CITY OF ALBUQUERQUE

March 22, 2019

**RE: Valle Prado Subdivision, Units 4 and 5
Tr 6, The Trails Unit 3A
Drainage Report Stamp Date: 3/8/19
Grading Plan Stamp Date: 3/7/19
Hydrology File: C09D011**

EXHIBIT C
PHASE 4 GRADING PLAN

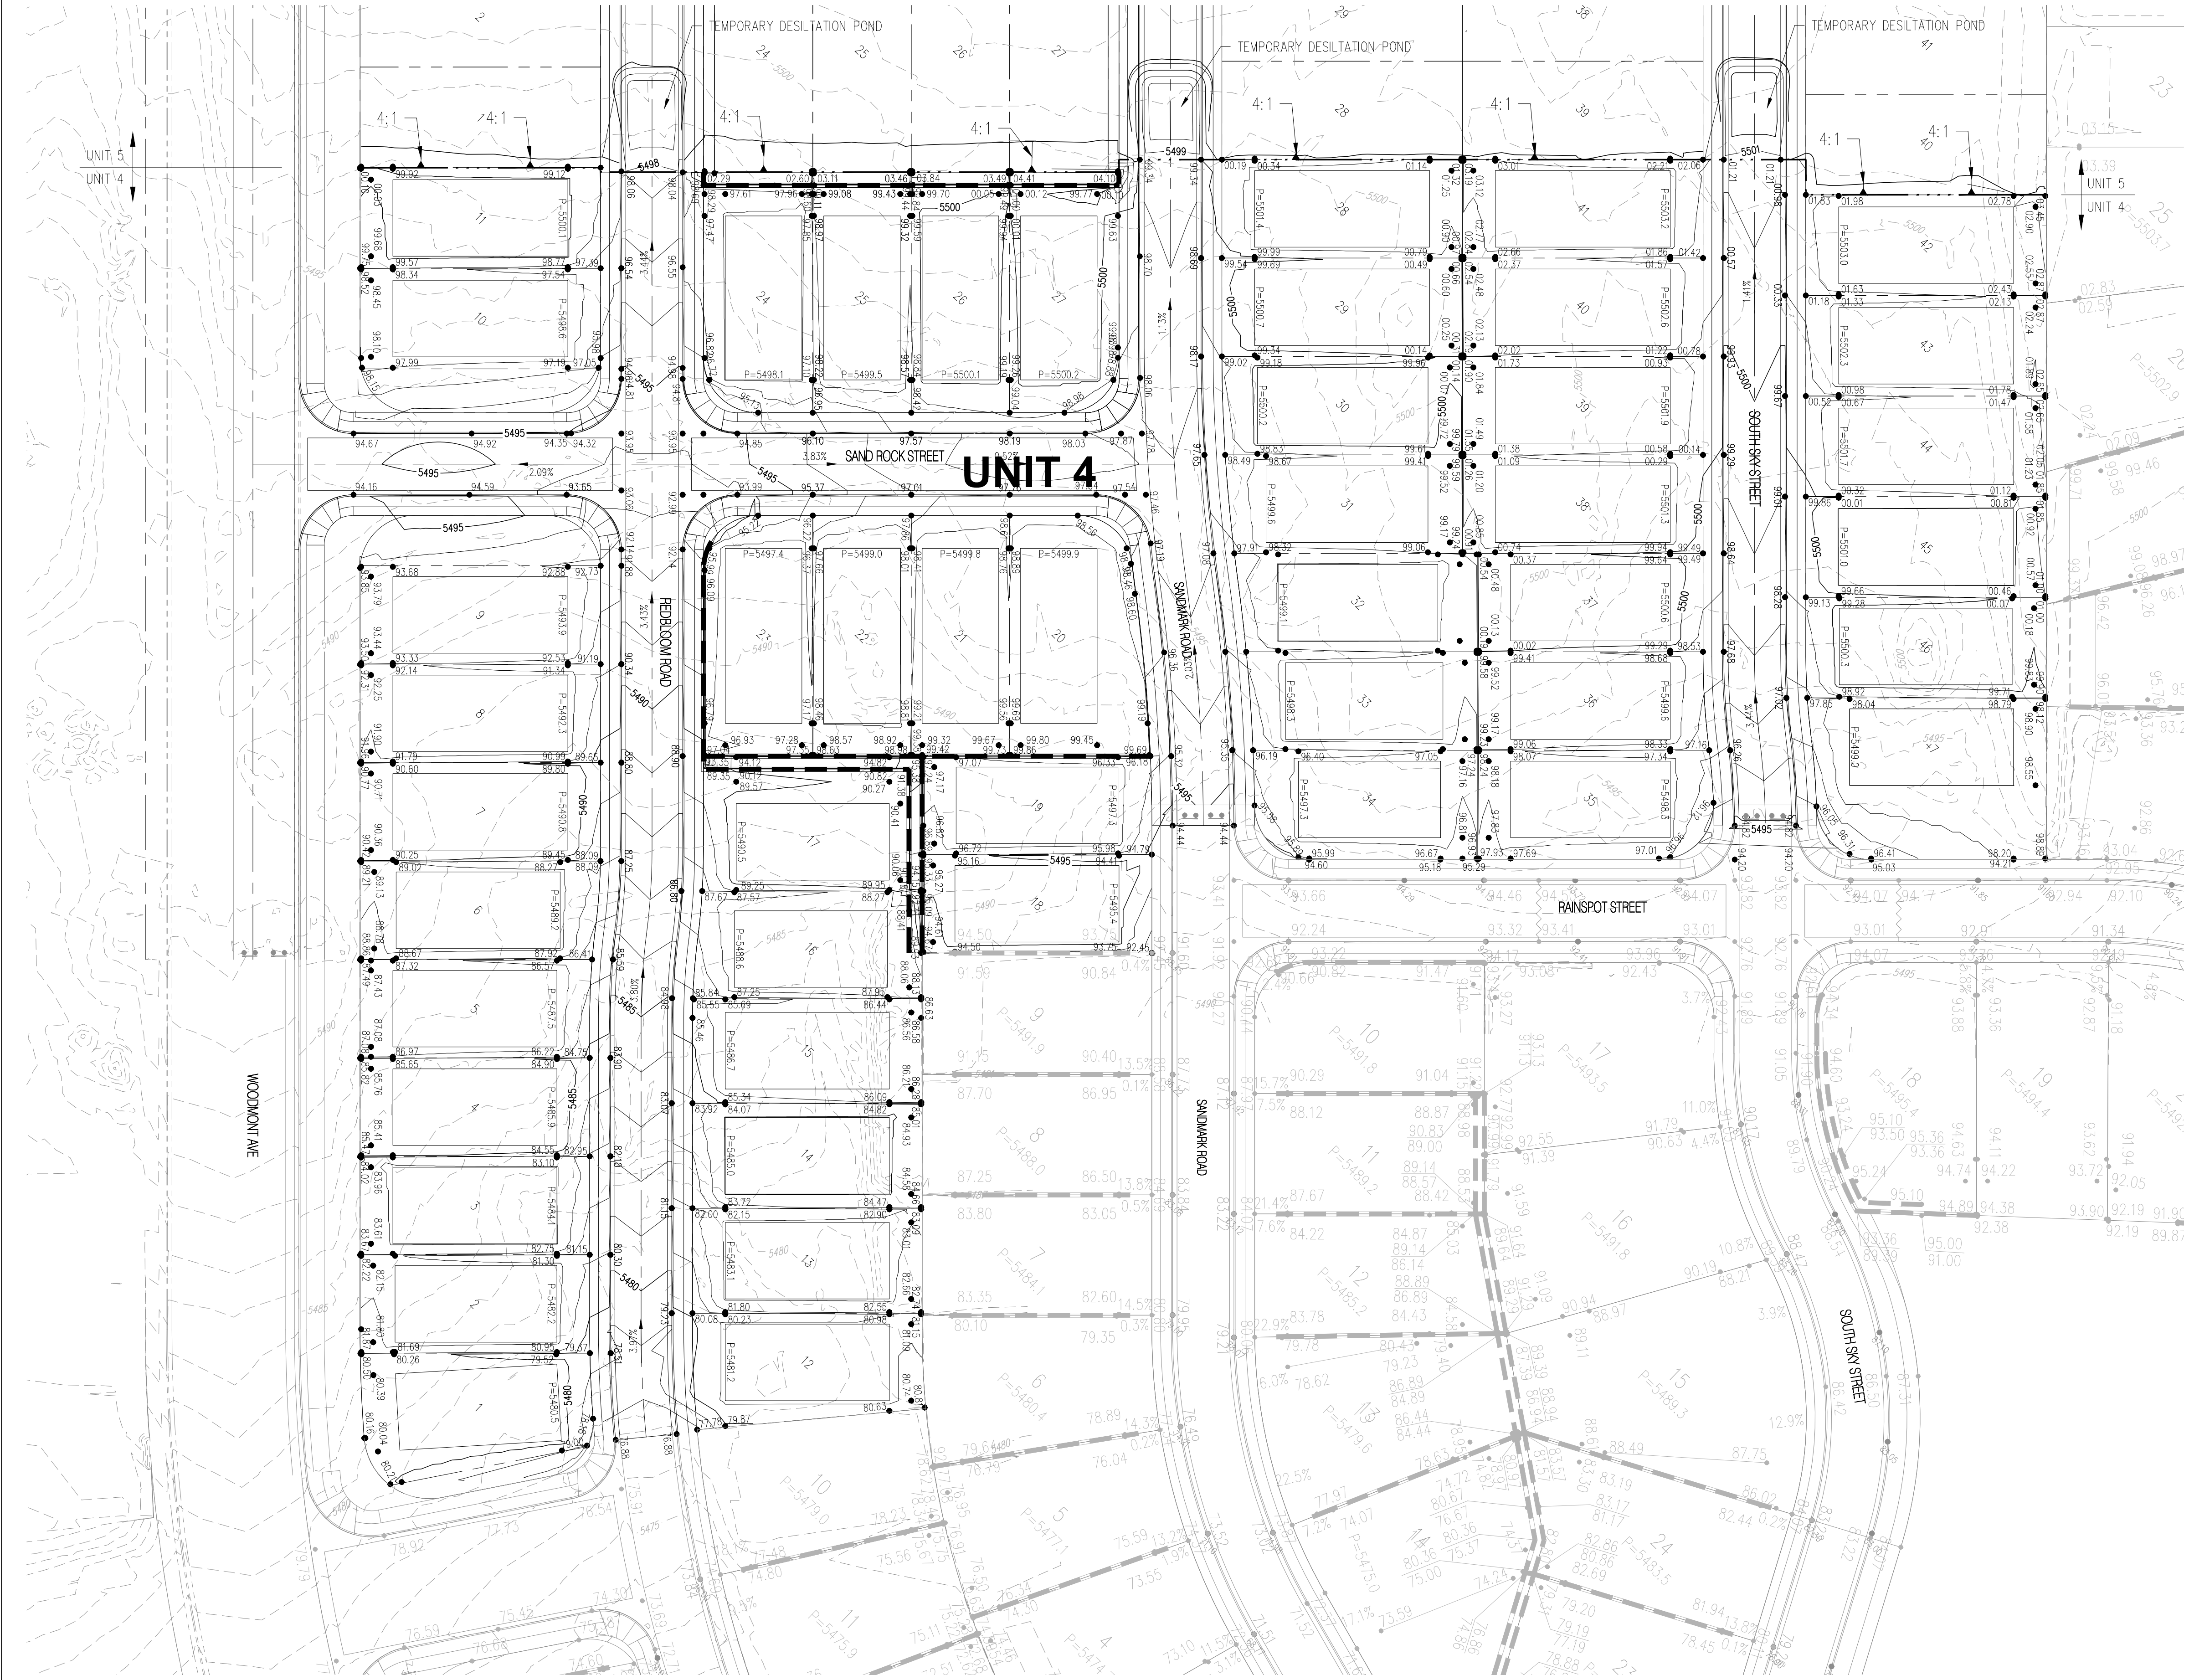
2. Engineer's Certification, per the DPM Chapter 22.7: *Engineer's Certification Checklist For Subdivision* is required.
3. Additional details are required for the cobble swale and will need to be provided on the Work Order plans: A channel detail will be needed, showing rock size & thickness, subgrade compaction, etc... Dimensional data needs to be provided, showing that the swale can convey the Q_{100} (2.7cfs).
4. Prior to Unit 4 ROFG, a temporary drainage easement on the temporary ponds will be needed, unless the upstream road portions have been built.

EXHIBIT D
PHASE 5 GRADING PLAN

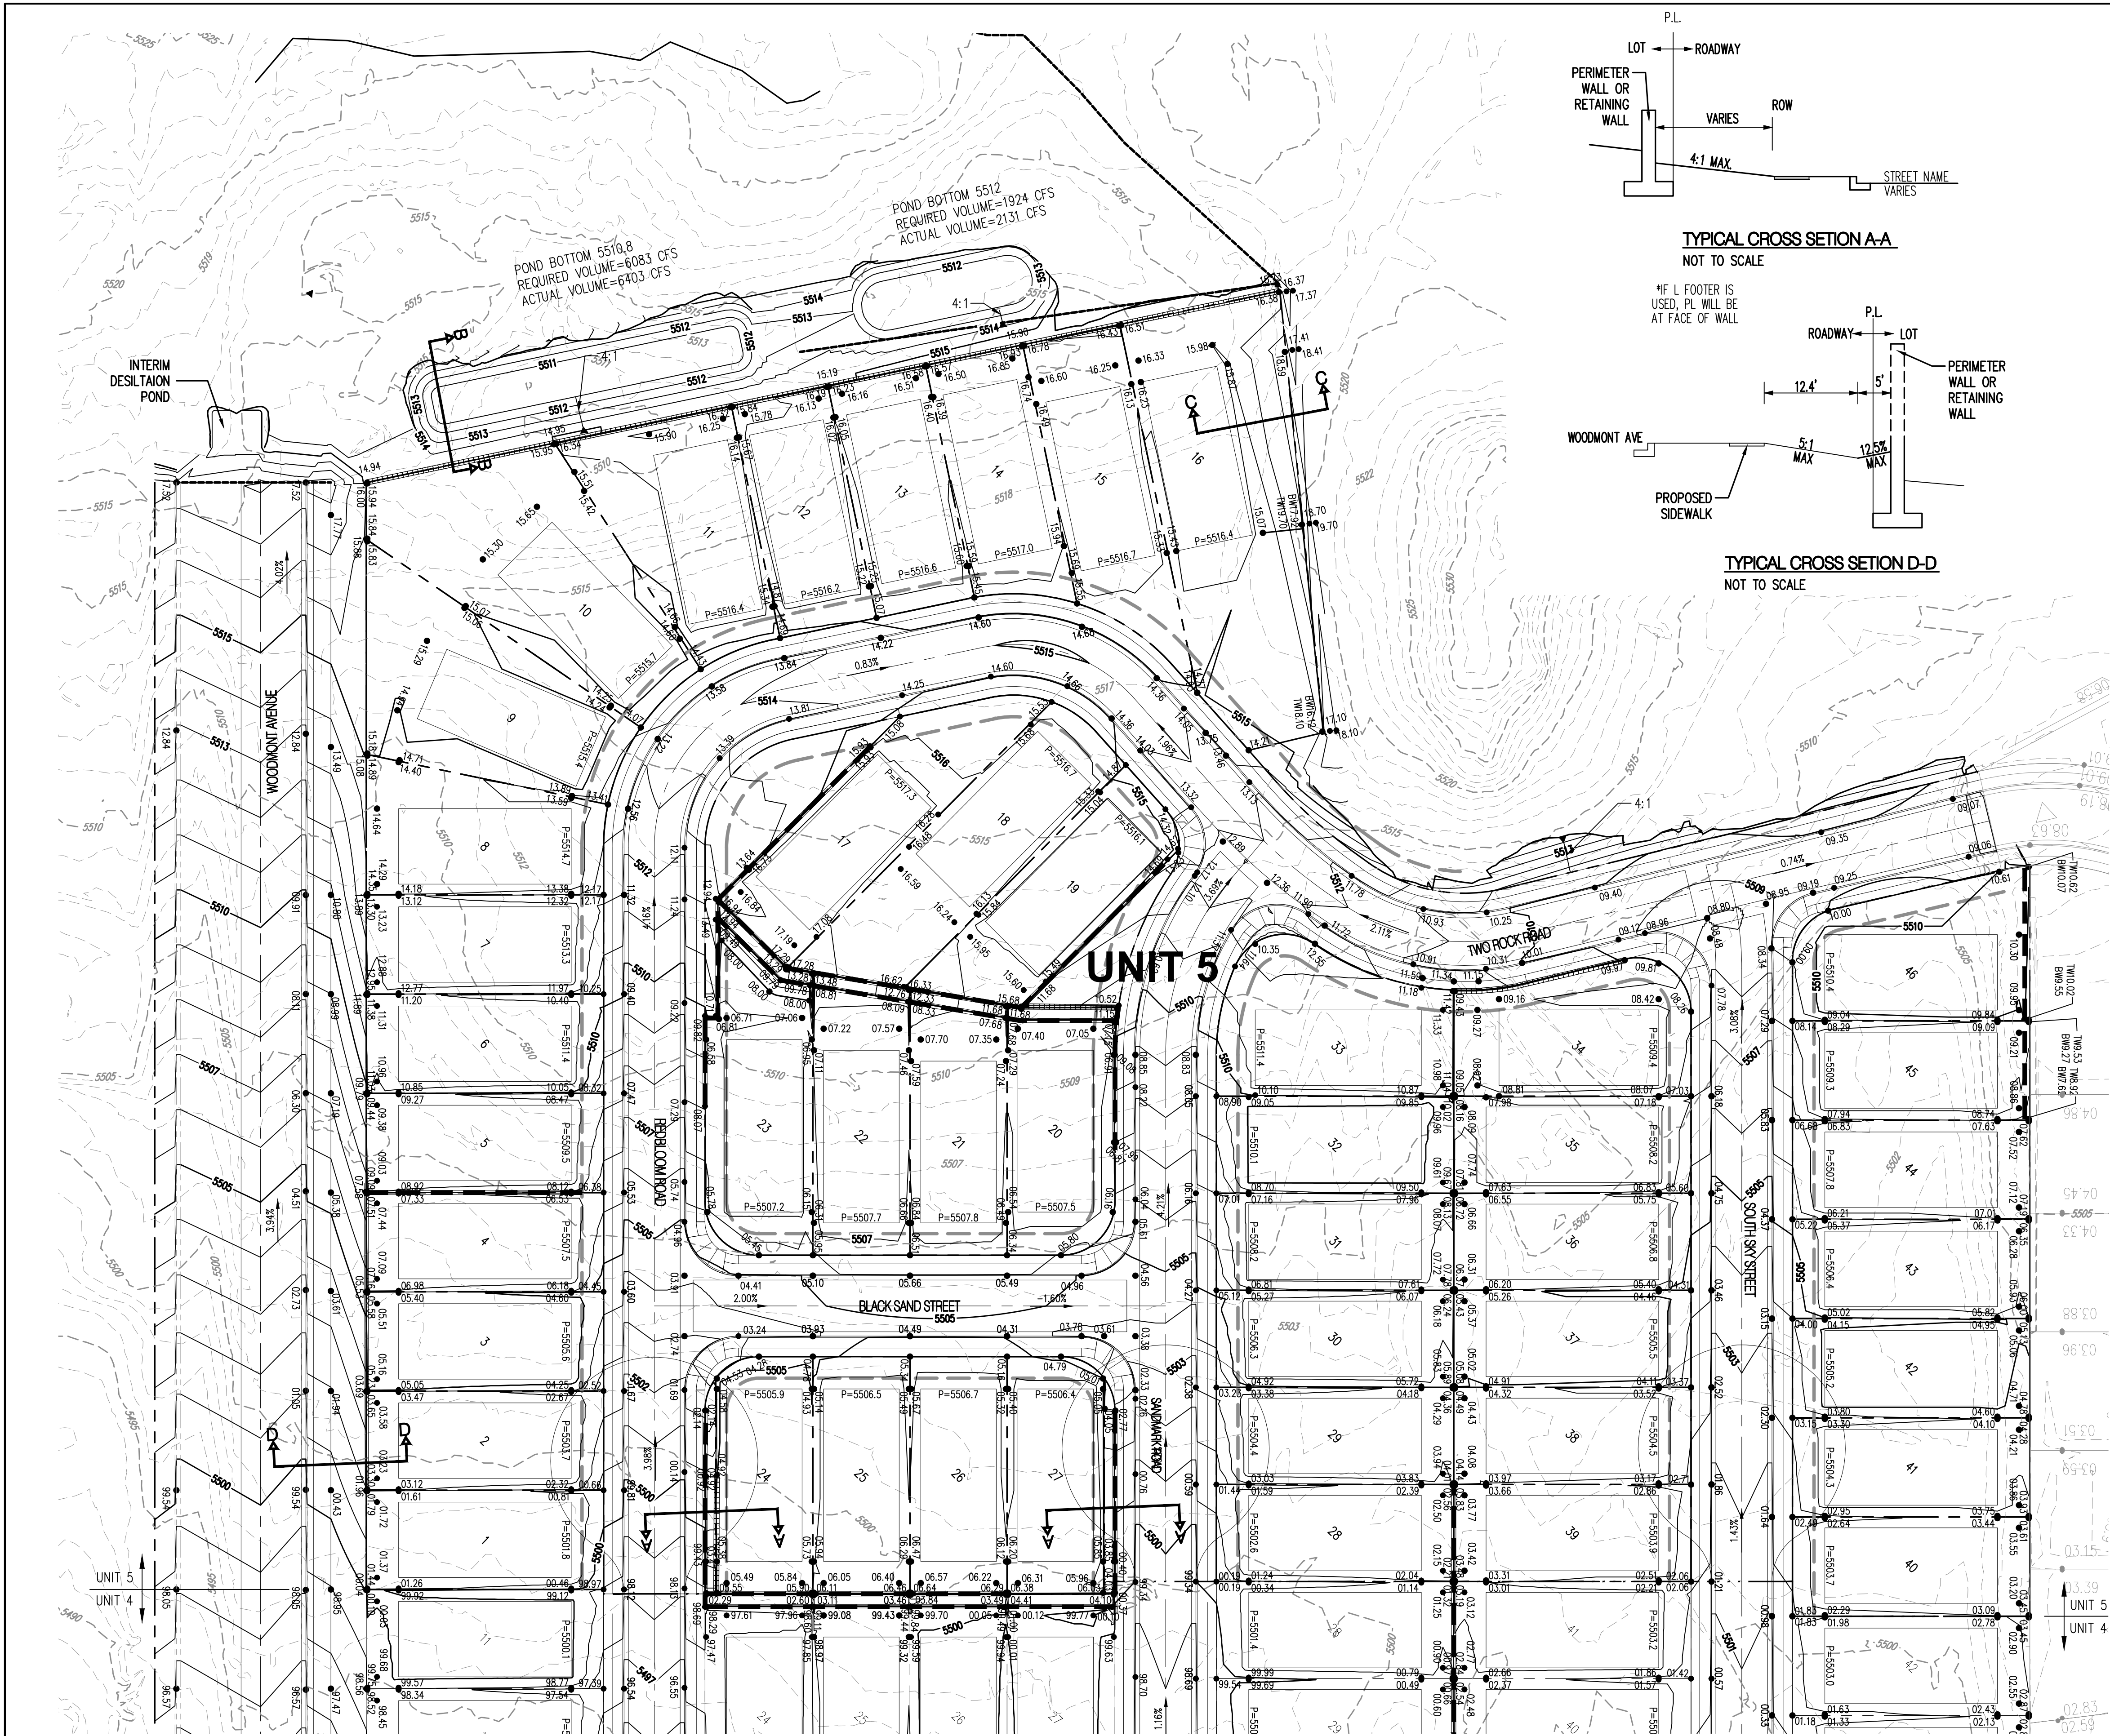
1. For Information. The interim pond on OS-2 must be named on the infrastructure list for Unit 5, along with drainage covenants and drainage easements. The pond should be called out as Interim Pond A-5, with the interim volume required and future volume required, per the Trails DMP (4.61ac-ft, per Thompson, 2015). It needs to be clear on the Work Order plans and the infrastructure list that the pond will need to be upsized again to accommodate future phases (or build the future configuration now).
